**FALCON HIGHLANDS FILING NO. 3
LETTER OF INTENT
SKETCH PLAN MAJOR AMENDMENT**

November 2, 2021

Challenger Communities
8605 Explorer Dr., Suite 250
Colorado Springs, CO 80920

As Proposed

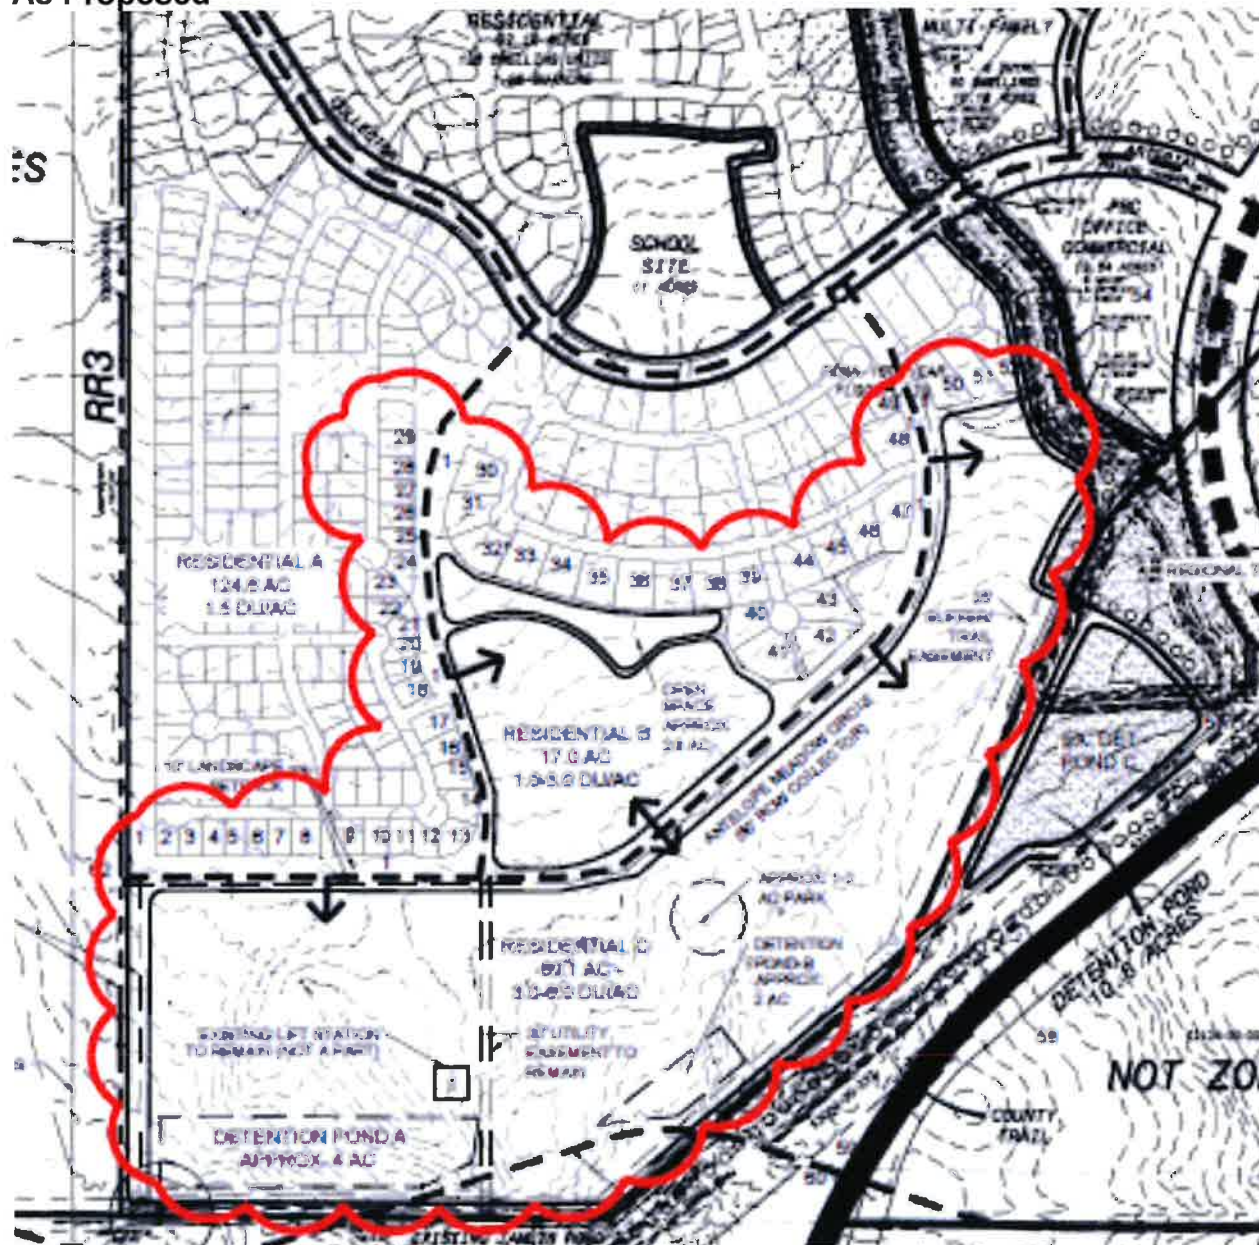
i recommend inserting the current skp in this area and adjacent PUD to provide a clear picture of what is currently approved ; this is to avoid some of the confusion that PC may have by not having context.

that does not add up with numbers on SKP

this does not match proposed density calcs or note on SKP
